From: Conservation Observations
Sent: 19 January 2021 11:28
To: Andrew Tew
Subject: RE: W/20/2113 - The Old Farm, Quarry Lane, Rowington, Warwick, CV35 7JQ

This response concerns an application submitted for Prior Approval for the change of use of an agricultural building into a dwelling at Old Farm, Rowington. The existing site comprises of a Grade II listed building, known as Old Farm, and curtilage listed outbuildings, with the existing barn located to the south of the main agricultural complex.

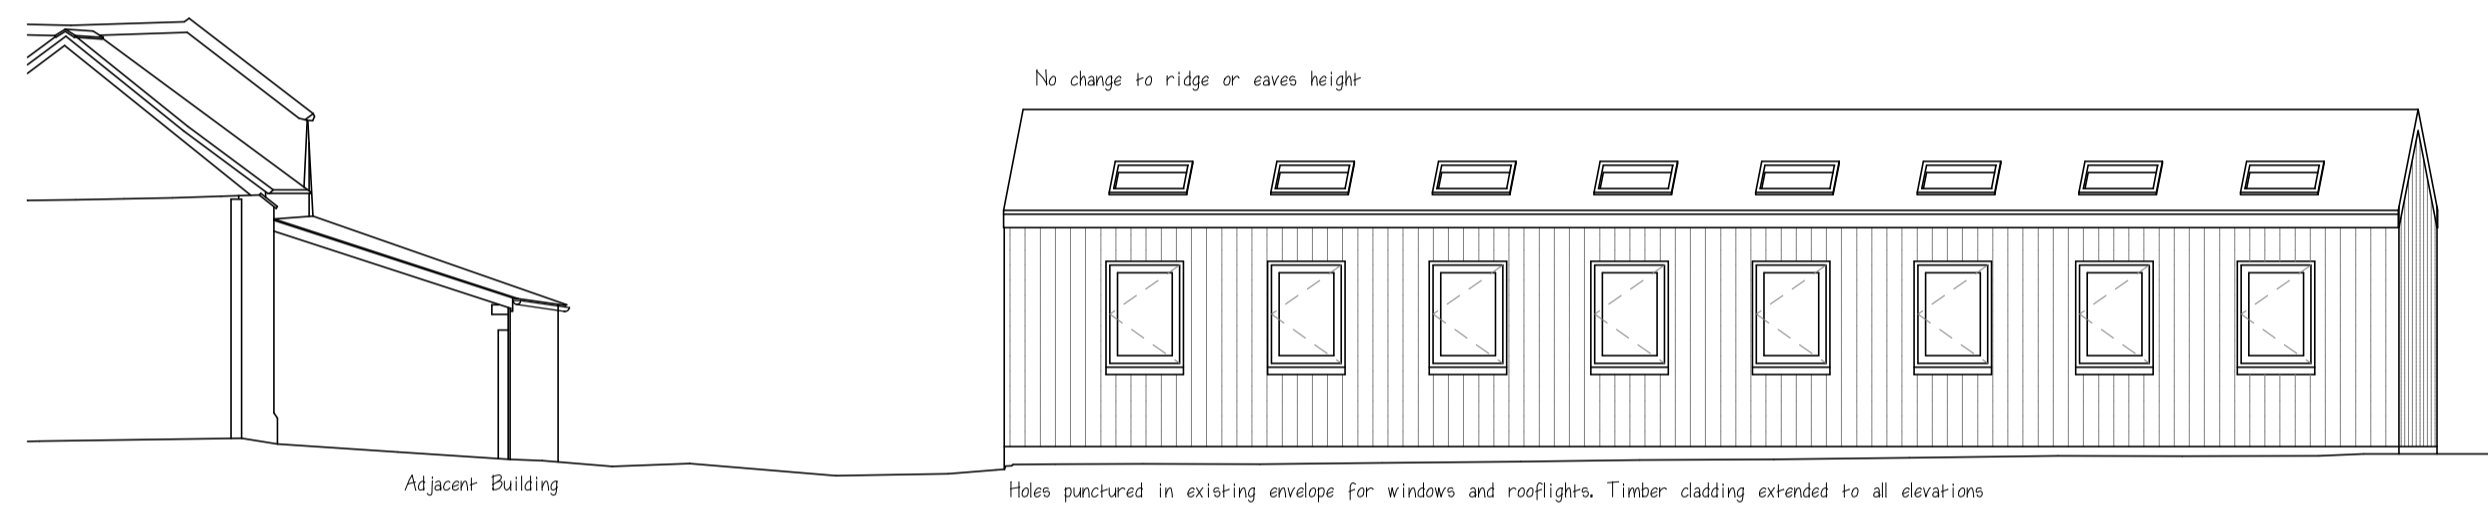
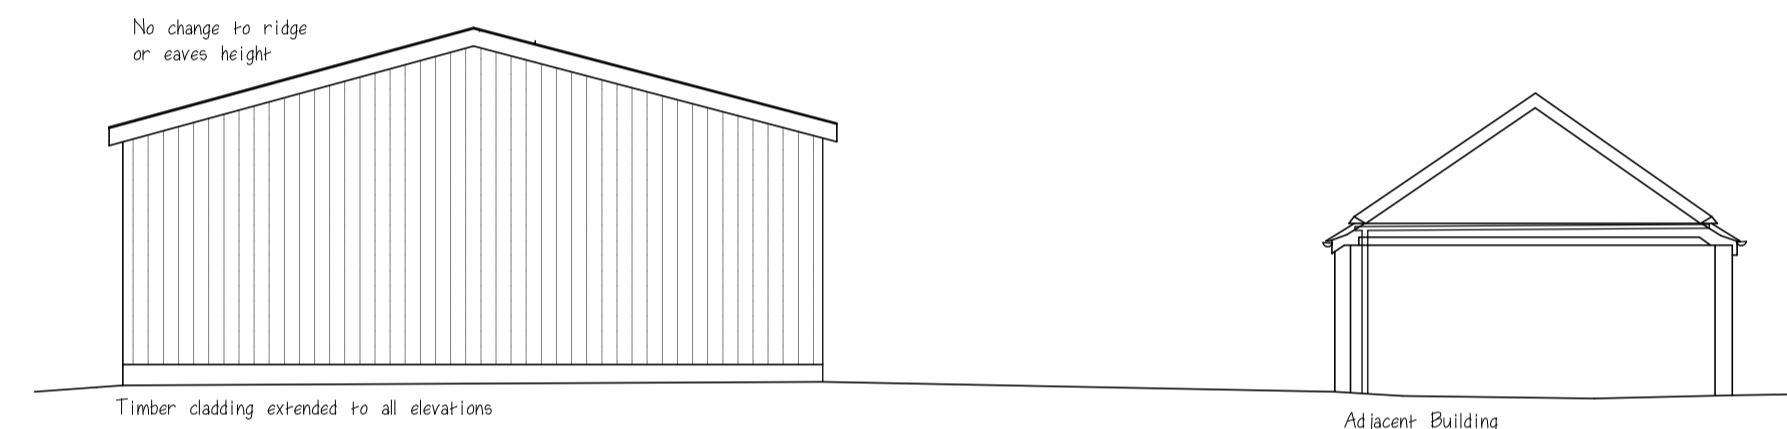
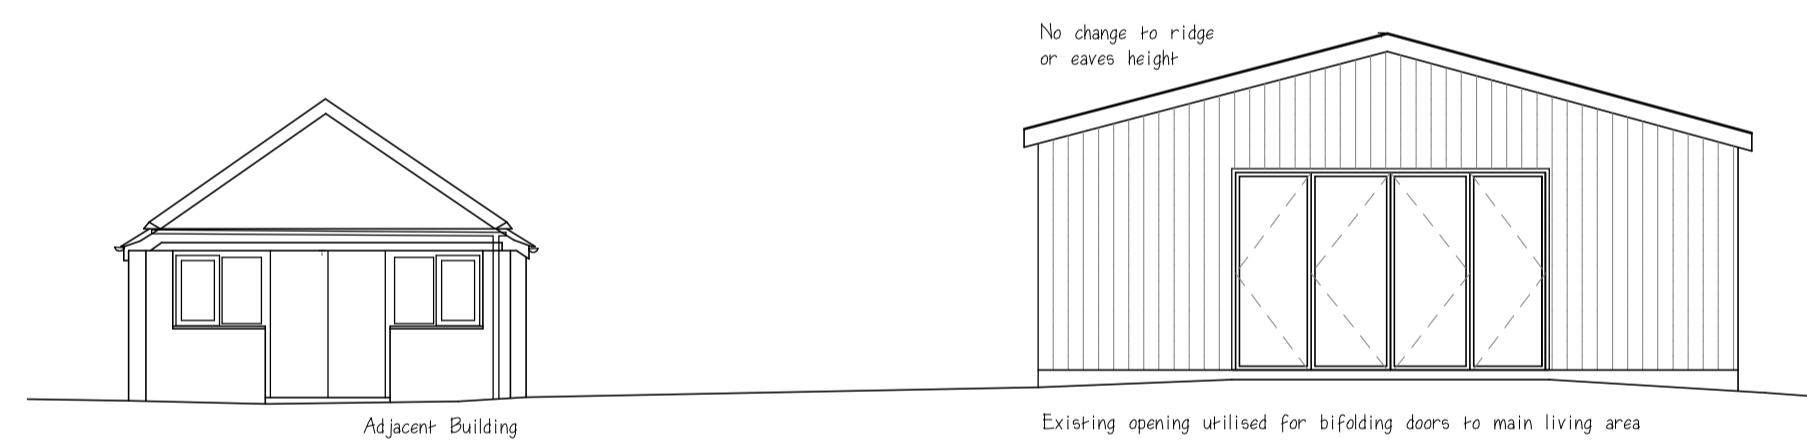
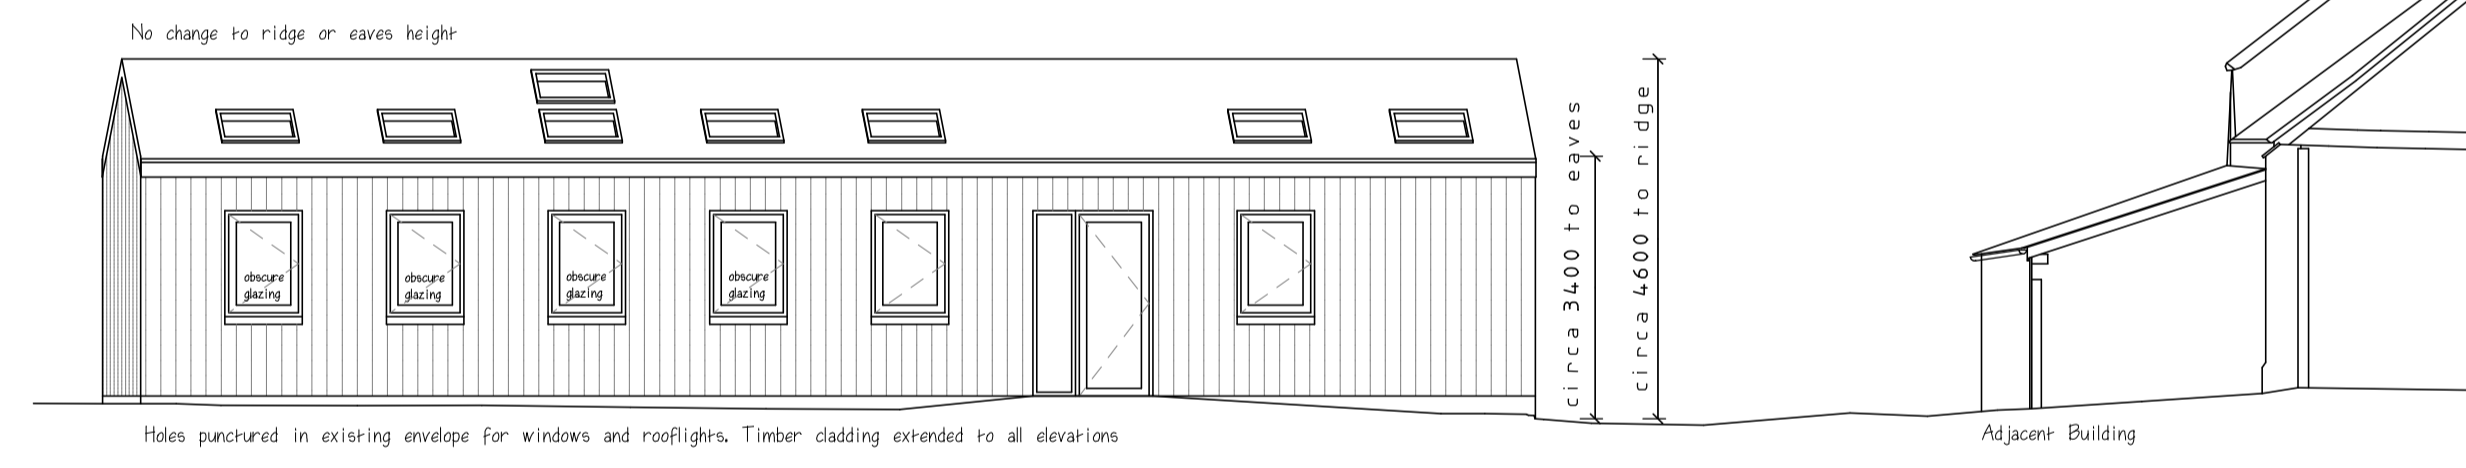
In its current form, we are unable to support the proposal as the scheme is considered contrary to the Council's [Historic Building Guidance: Agricultural Buildings and Conversion – Barns](#) SPD and policies HE1, BE1 and BE4 of the Local Plan. The number of proposed new openings (roof lights and windows) is excessive, resulting in a clear departure from the original agricultural characteristics of the site which is also considered harmful to the setting of the listed building. The agent/applicant should consult this guidance in order to gain an understanding of what we would consider acceptable for conversion of agricultural buildings.

The aforementioned SPD explains that barns are an important and valuable feature of the landscape. Their acceptability for conversion will depend firstly upon meeting the Local Plan policy criteria of the District Council where appropriate and secondly upon achieving proper standards of design and appearance. The introduction of inappropriate design elements can be highly destructive to the character, historic fabric and setting of a former barn or agricultural complex. With the exception of the occasional pitching loft, roofs on barns and other agricultural buildings are characterised by their unbroken lines and total lack of any openings. It is essential that this quality is retained in any conversion work. The addition of roof lights can disrupt the visual appearance of the roof; if additional daylight is required, consideration, in the first instance, should be given to using unobtrusive openings in gable ends or utilising existing openings such as pitch holes etc. Roof lights should also be modest in size, located flush with the roof pitch, restricted to the absolute minimum and certainly located below the centre line of the roof slope, preferably in the bottom third and related to the scale of the existing building. Consideration should be given to varying the size and position of any new roof lights to avoid excessive symmetry and produce a more visually appropriate solution. Nothing is so visually obtrusive as the distinctive patches of reflected light produced by a number of inappropriately sized and located roof lights. In some situations it may be appropriate to use an area of patent glazing in lieu of roof lights. With the exception of the main cart doors and ventilation slots, barns are characterised by their lack of openings. Windows in particular are an alien feature and as a consequence their introduction has to be handled with extreme care to avoid adversely affecting the character of the building. New windows should only be located to provide the necessary daylight and not to provide views out, with new openings kept to an absolute minimum.

The application is considered contrary to the aforementioned policy and guidance and we therefore object to the proposal in its current form.
